HyNet North West

SCHEDULE OF CHANGES TO THE dDCO

HyNet Carbon Dioxide Pipeline DCO

Document Reference Number D.3.3

**DRAWING TITLE**  
**WORKS PLAN REGULATION 5(2)(i) APPLICATION DOCUMENT REFERENCE D.2.4 SHEET 3**

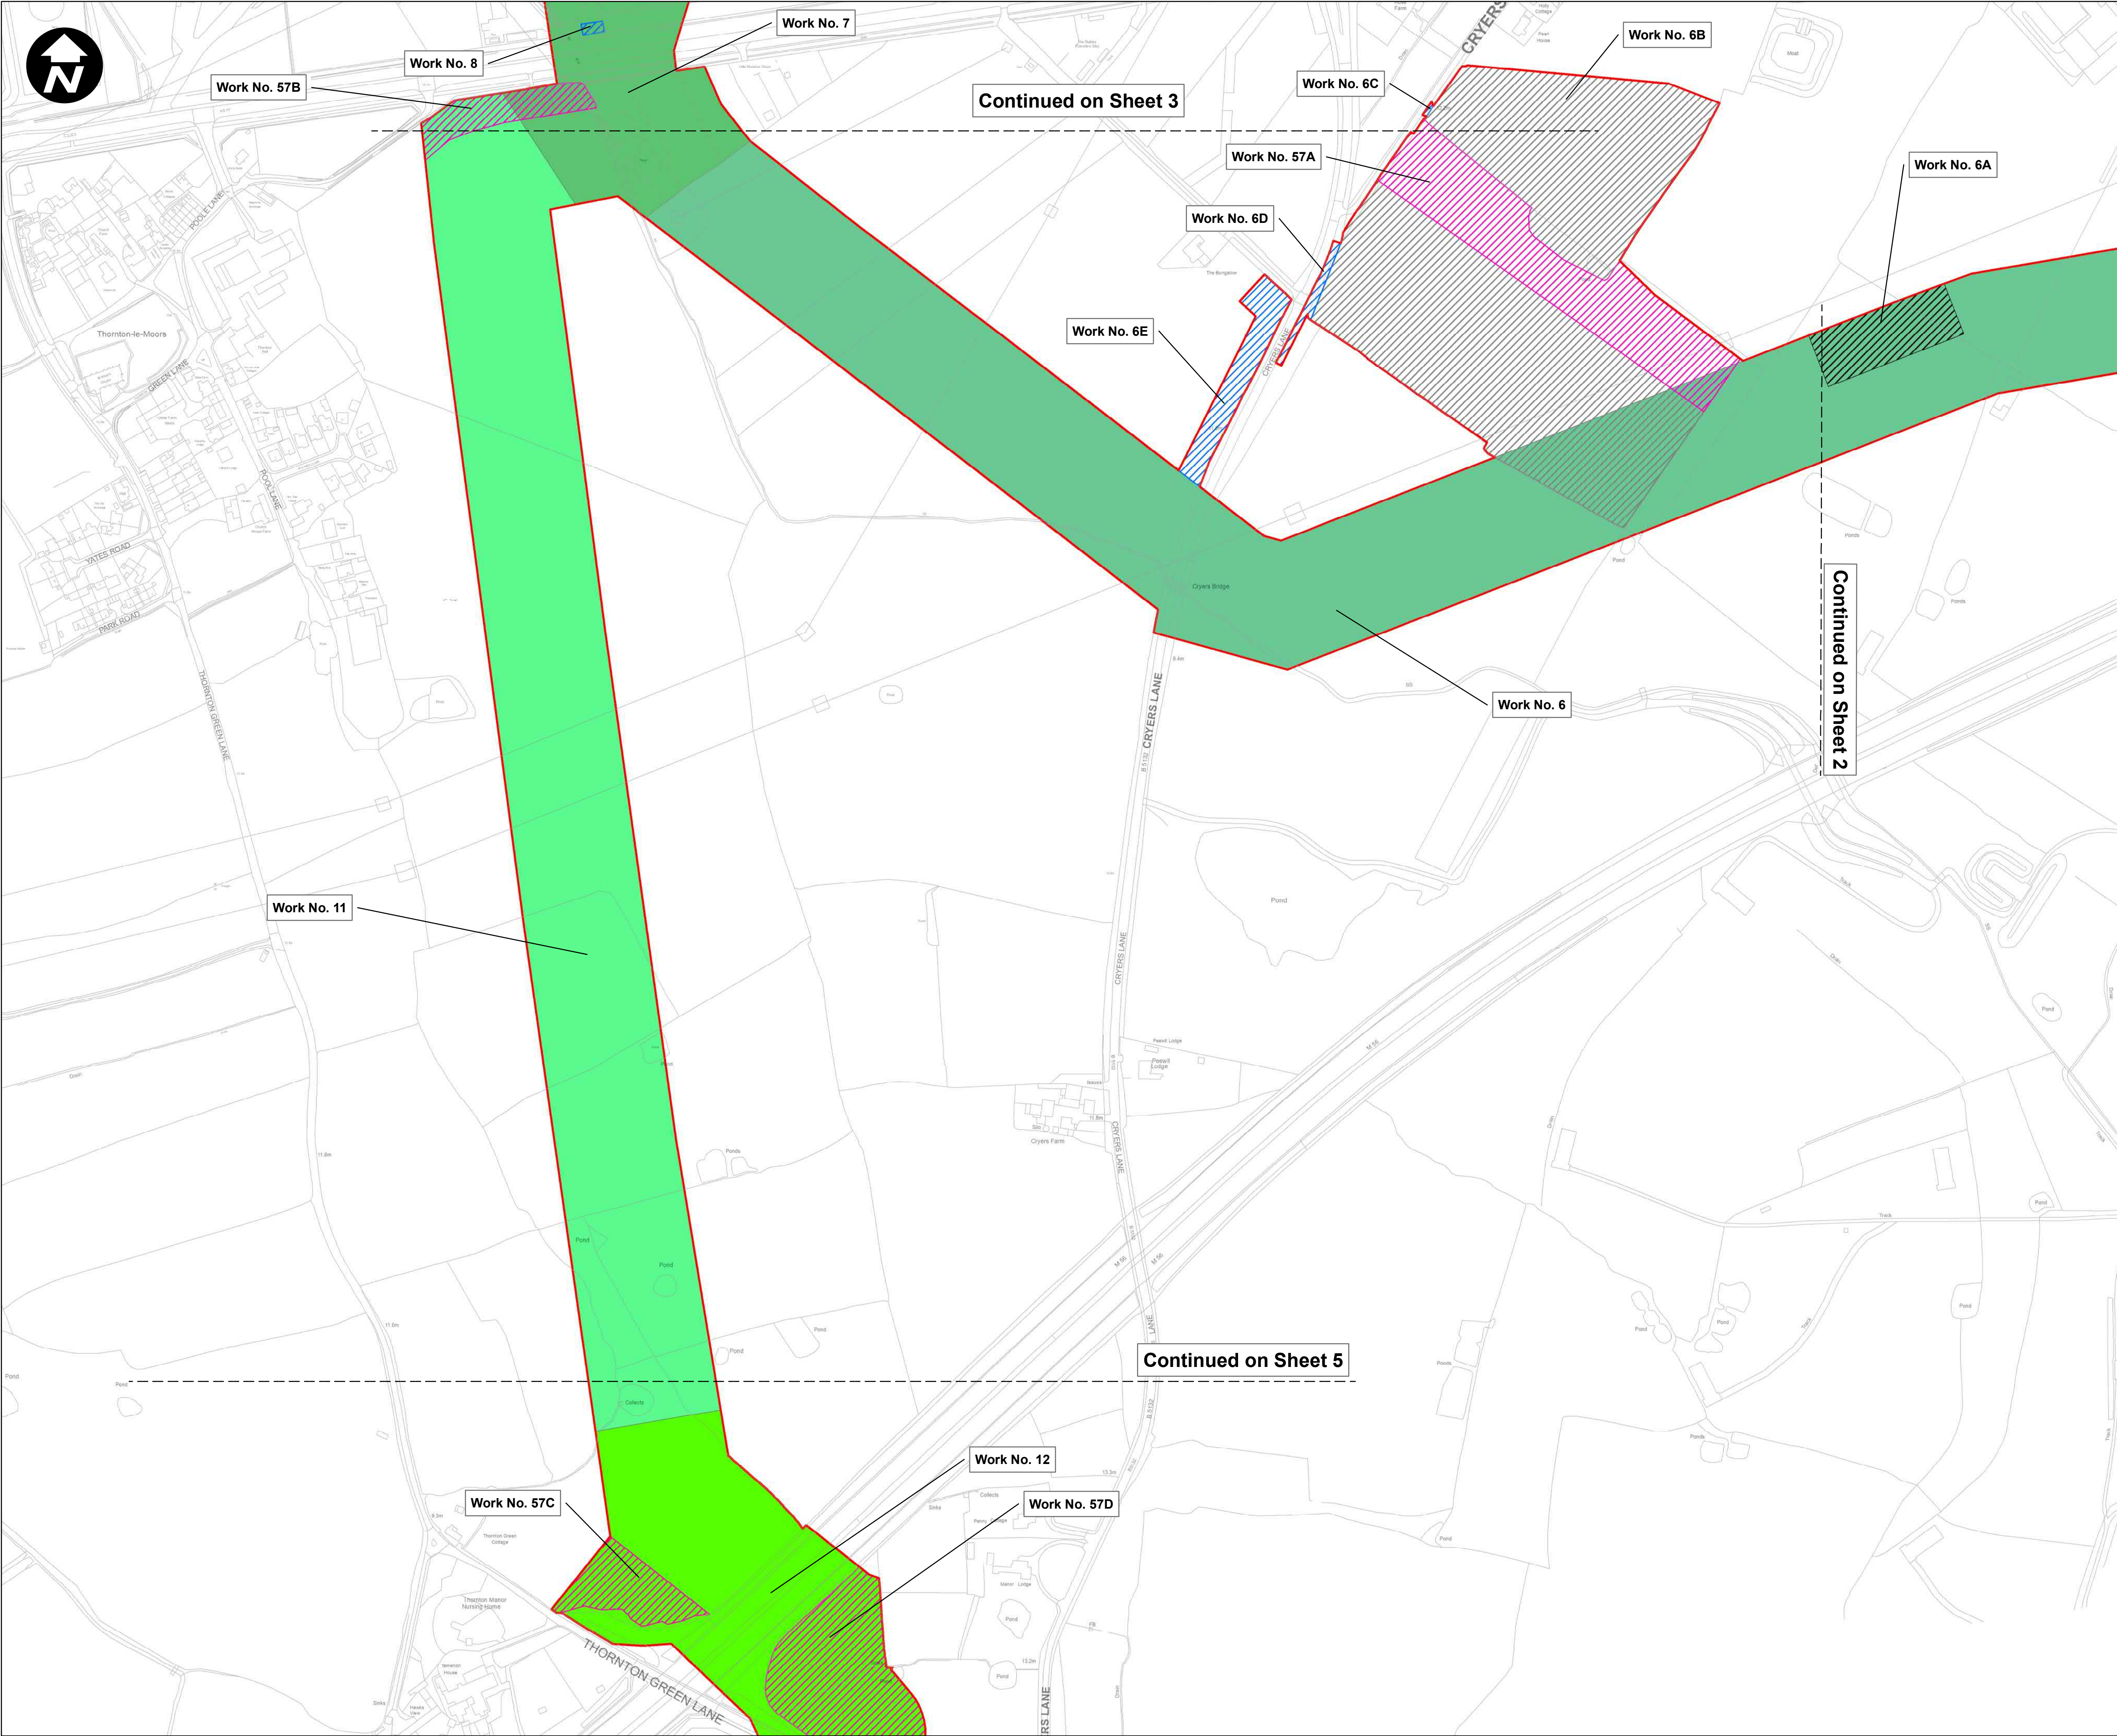
Reference	Amendment	Reason
Articles		
n/a		
Schedules		
Schedule 1 (authorised development)	Minor corrections from 'Work Plans' to 'Works Plans' throughout and insertion of missing 'and' in lists.	For consistency.
	The Works descriptions were amended as follows: <i>Work No. 3:</i> The creation and use of a permanent vehicular access to the authorised development, from the Pool Lane/Oil Sites Road roundabout via the unnamed road (private road) and via the unnamed road (private road) from Ash Road unnamed road within the location shown on Sheet 1, Sheet 1a and Sheet 3 of the Works Plans, including—	To reflect the changes sought as part of the change request.

**EN070007-D.2.4-WP-Sheet 7**

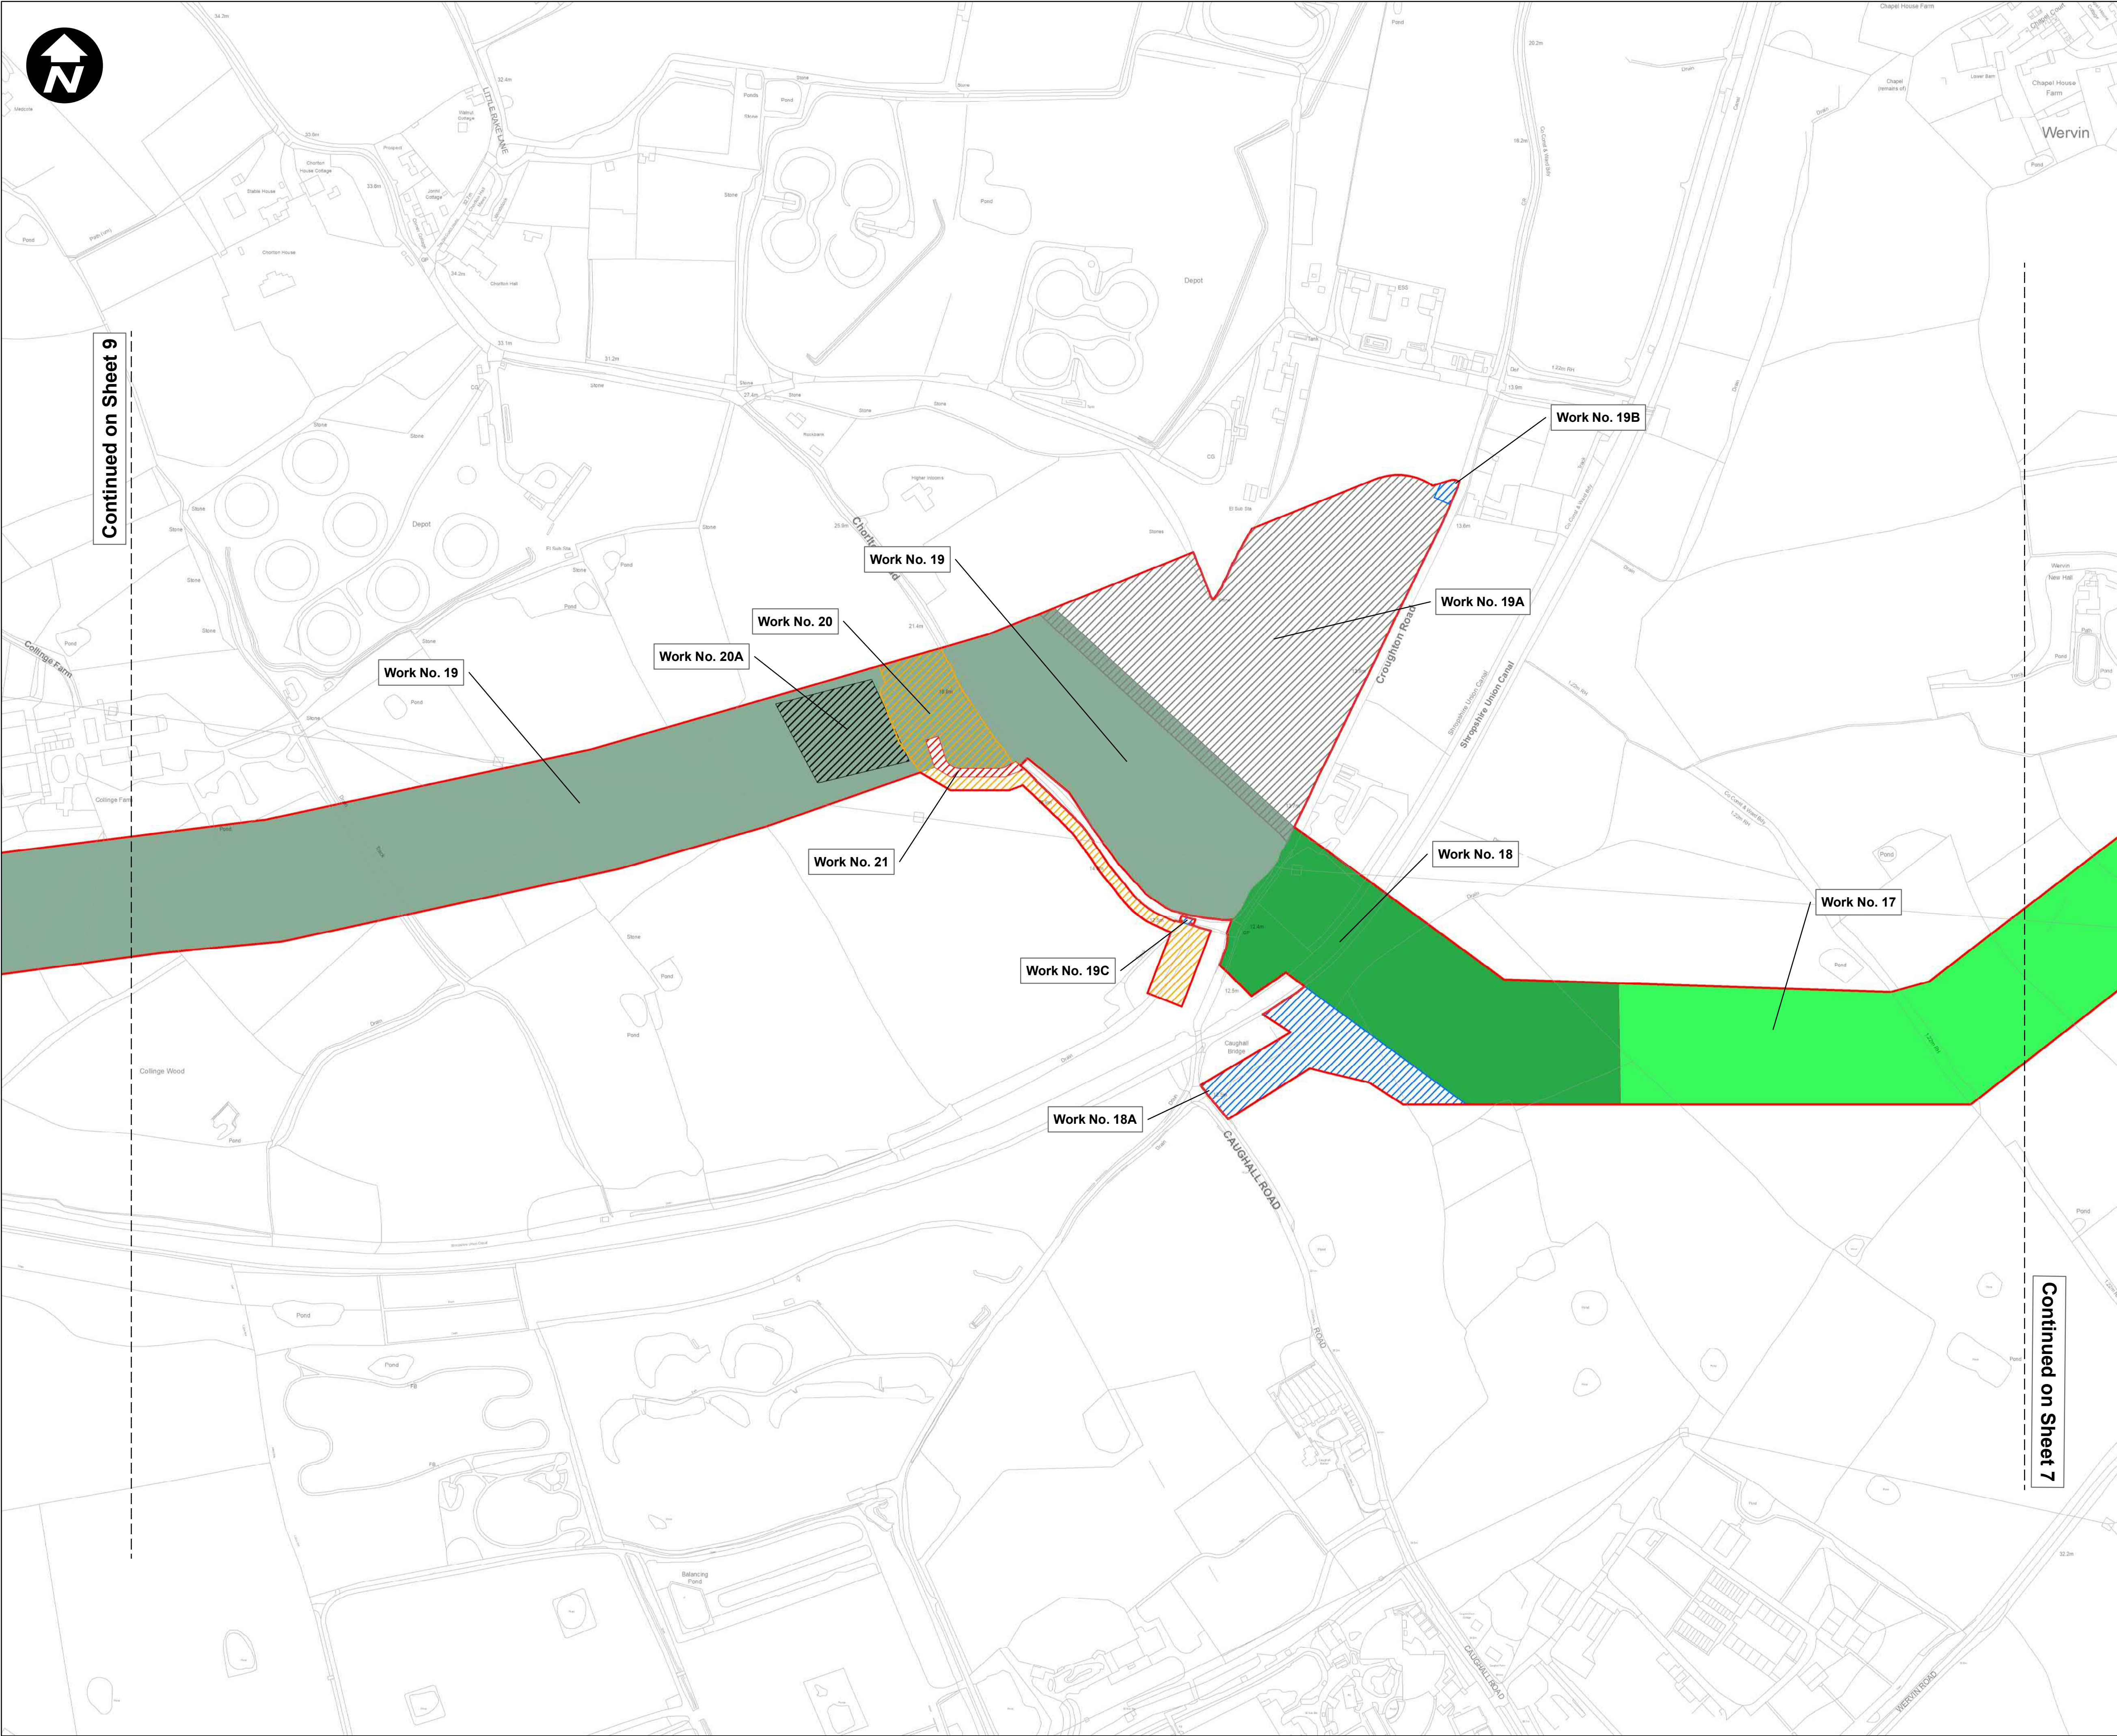
2. <i>Work No. 16A:</i> Creation and use of a permanent access from Picton Lane, within the location shown on Sheet 7 of the Work Plans, including— 3. creation of a new bellmouth junction with the public highway; and improvement of road surfacing and provision of new hard surfacing (excluding on the Bridleway) .	To reflect the changes sought as part of the change request
	New Work No. 16B inserted;	To reflect the changes sought as part of the change request

<p><u>Work No. 16B: Creation and use of a temporary construction access from Picton Lane, within the location shown on Sheet 7 of the Works Plans, including—</u></p> <p>a. <u>creation of a new bellmouth junction with the public highway; and</u></p> <p>b. <u>improvement of road surfacing and provision of new hard surfacing.</u></p>	
	<p>Work No. 32A: Creation and use of a temporary construction access from the B5129 private track, within the location shown on Sheets 14 and 15 of the Works Plans, including—</p> <p>improvement of an existing junction with the public highway; and</p> <p>improvement of road surfacing and provision of new hard surfacing</p>	<p>To reflect the changes sought as part of the change request</p>
	<p>New Work No.45B inserted;</p> <p><u>Work No. 45B: The creation and use of a permanent vehicular access to the authorised development, from B5125 within the location shown on Sheet 20 of the Works Plans, including—</u></p> <p>a. <u>improvement of road surfacing and provision of new hard surfacing;</u></p> <p>b. <u>creation of a new bellmouth junction and visibility splays; and</u></p> <p>c. <u>installation of utilities.</u></p>	<p>To reflect the changes sought as part of the change request</p>
